THE TARONGA ZOO – New reptilian conservation centre at Taronga Zoo

❖ *Comments from the Mosman Parks and Bushland NGO group.*

THE RESPONSE to the above, plus research of the Urbis Document plus Toronto ZOO comparison :

E1 OVERALL NORTH ELEVATION
1 : 100

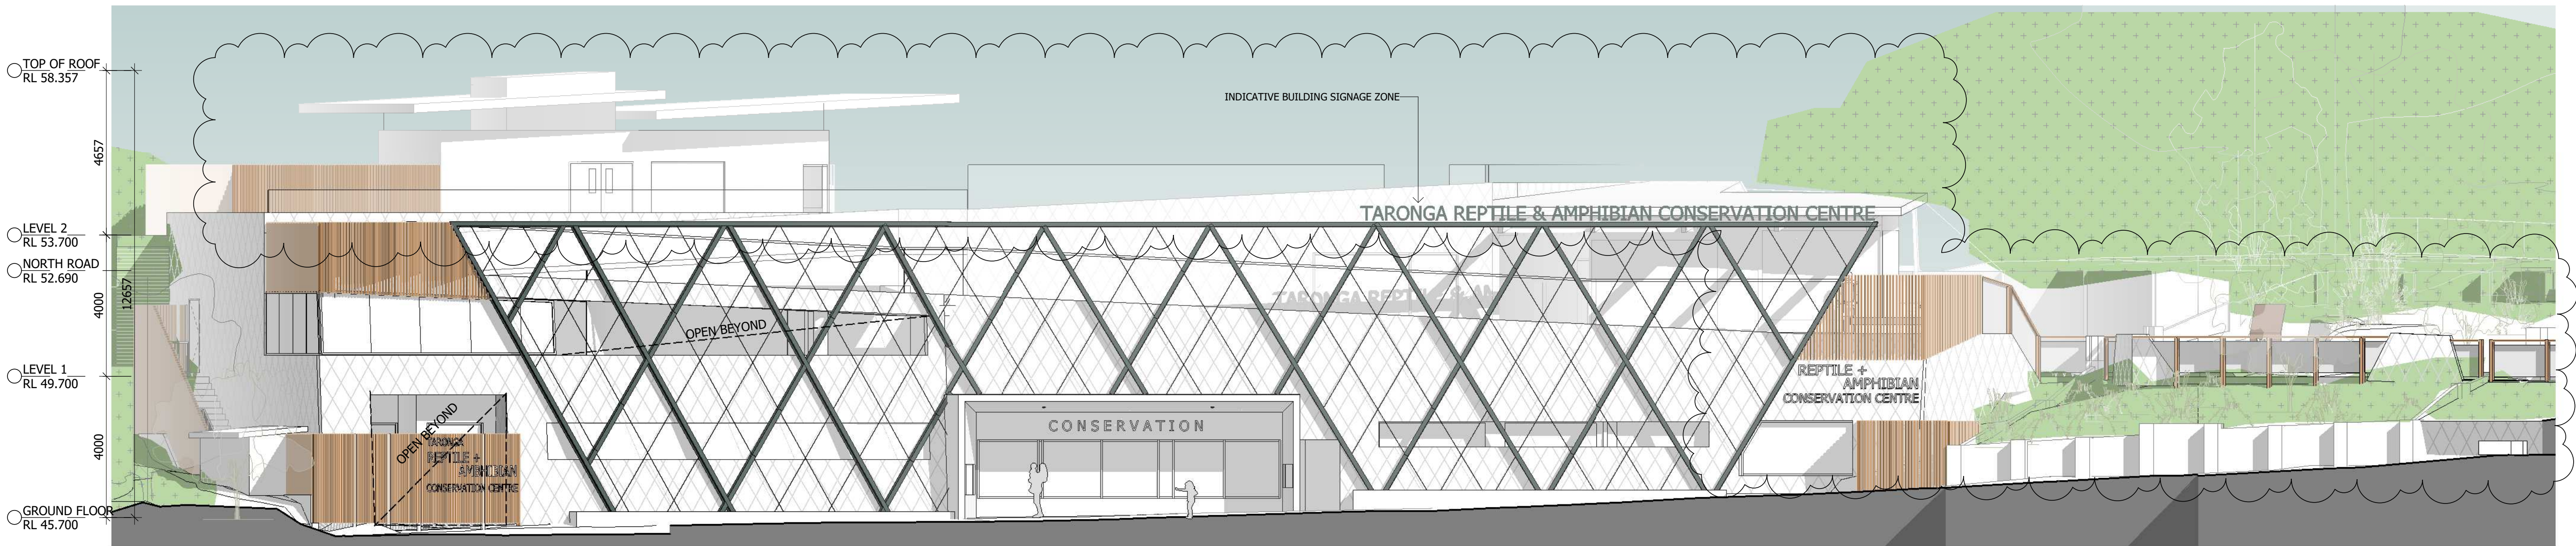
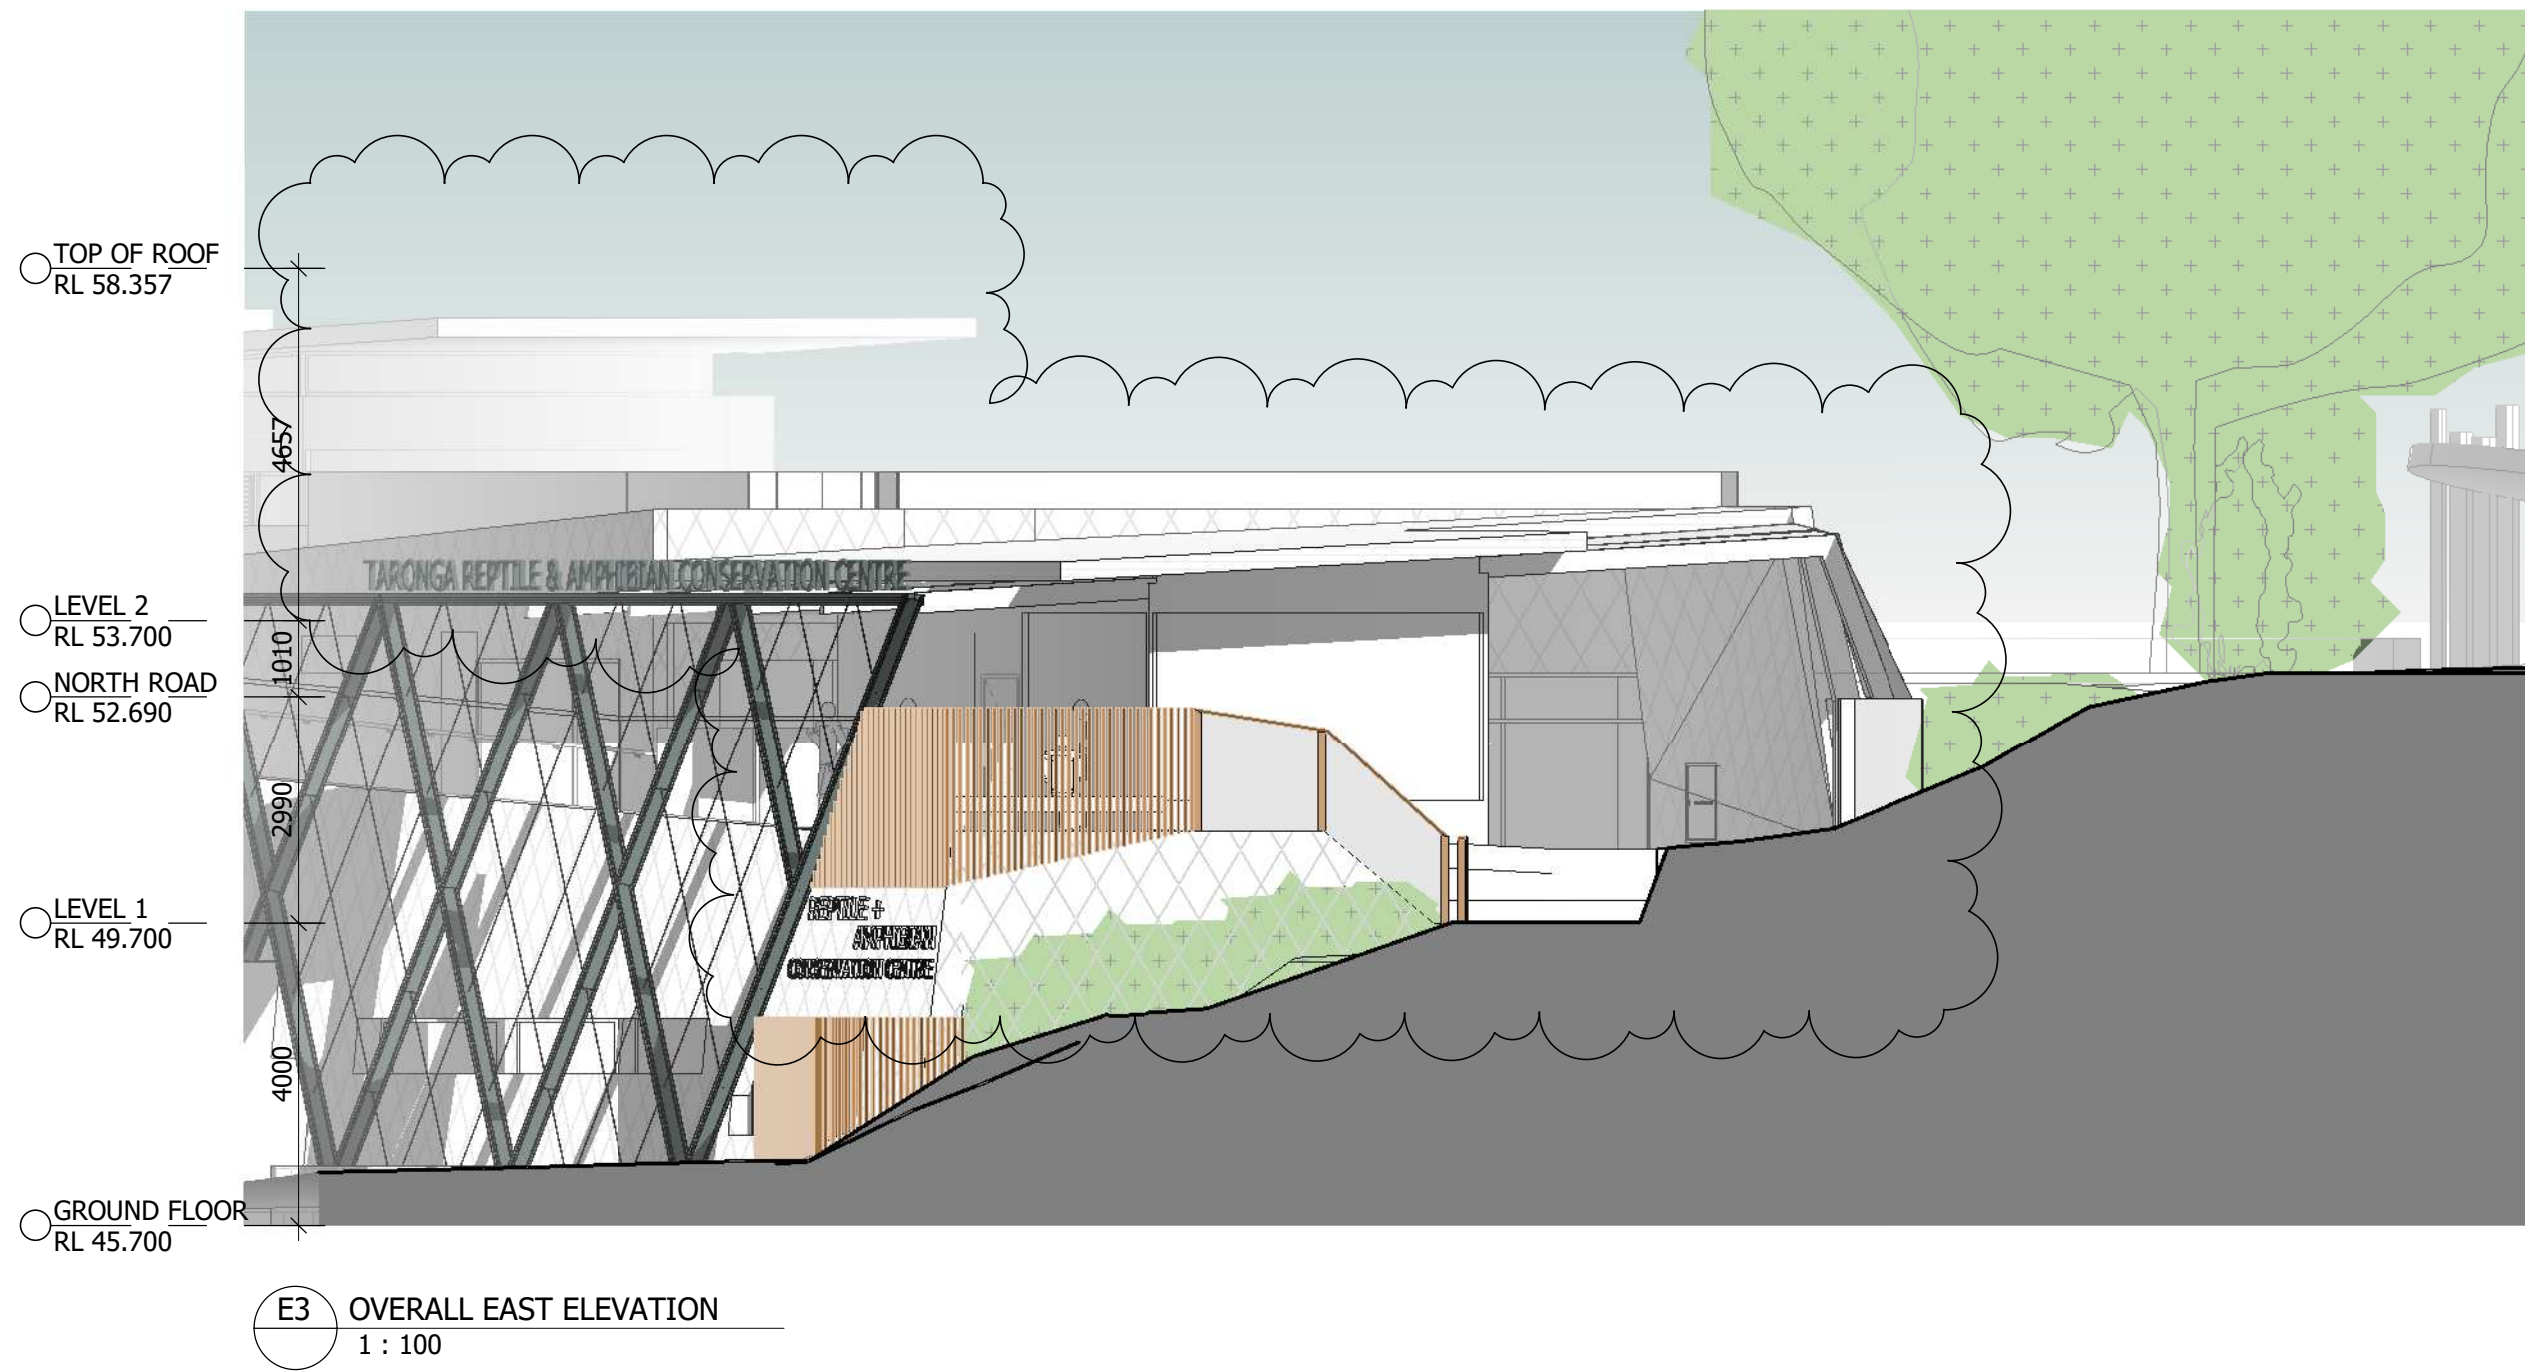
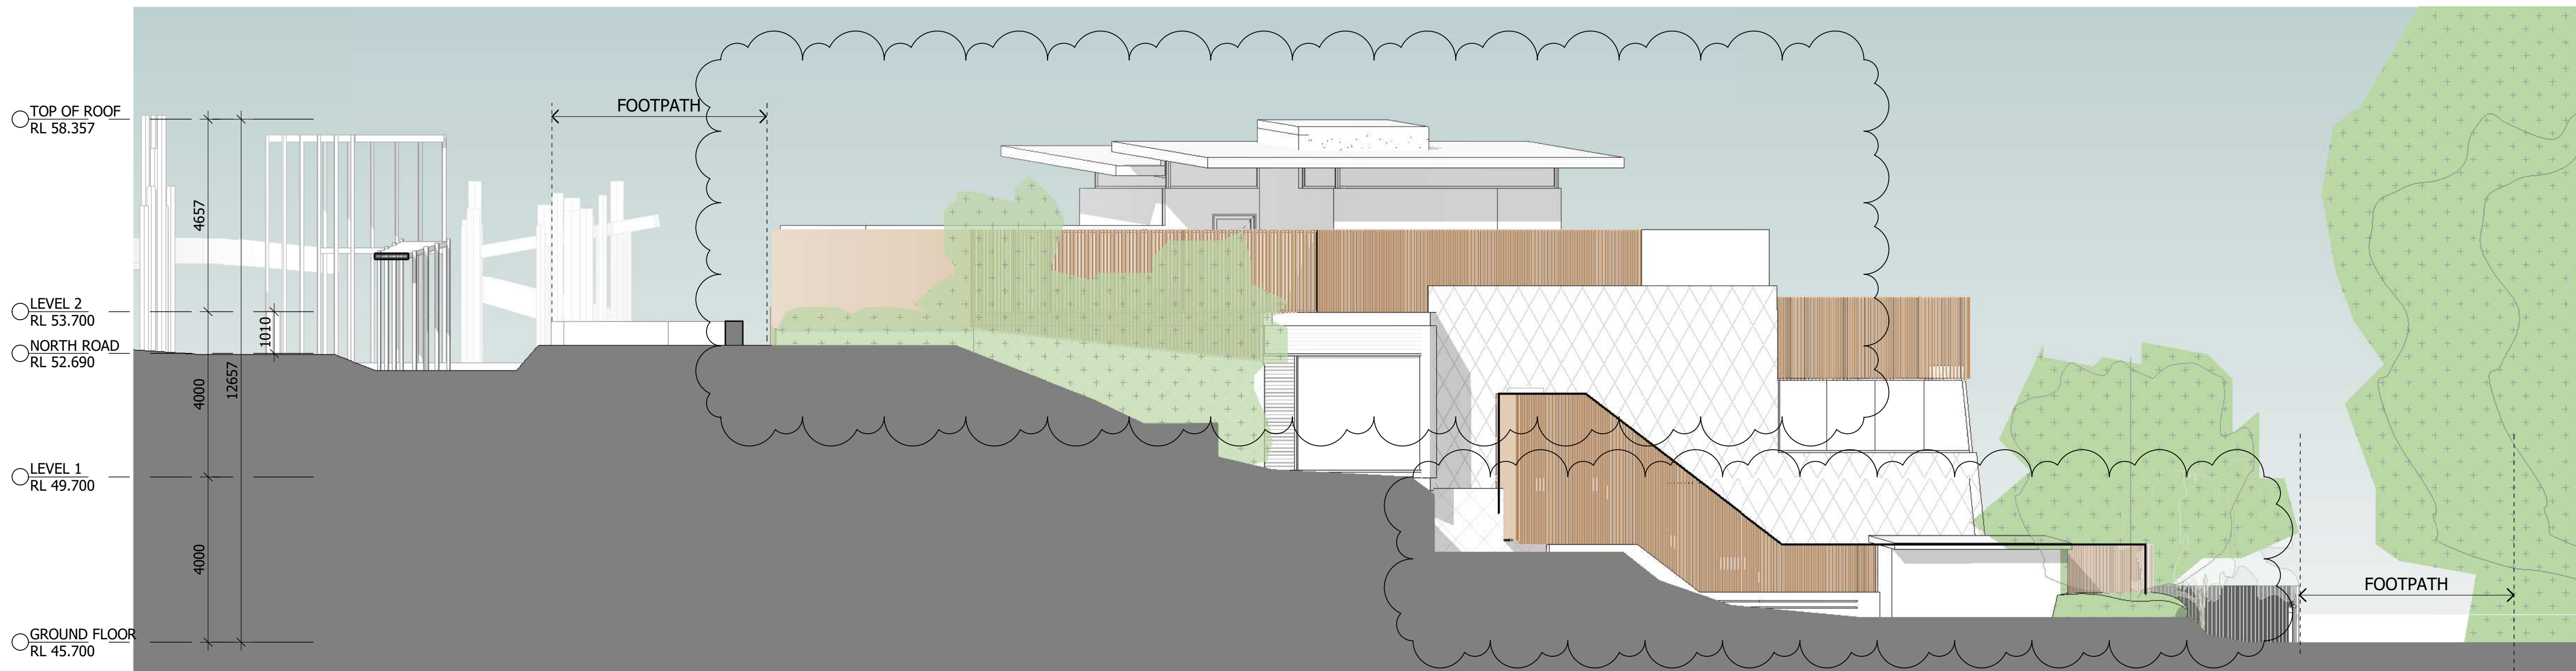
8. The overall “Architectural Concept” seems to LACK a GOOD BIO-PHILIC solution, using a vertical ship-lap detail, to prove its “natural looks”. (But it could be Brown Concrete? To ensure it is Fire-safe)

9. The wood panelling look on the bottom level could be replaced with Sandstone Cladding ?
10. Perhaps a “Green Roof overhead” of flowering Native Plants can “increase the bushland of Taronga Zoo”?

21. DWP’s design will see the building nestled into the site to lessen the overall bulk and scale of the built form. The three levels cascade down the steeply sloping site, with a green wall screen structure on the southern elevation working to conceal the building.
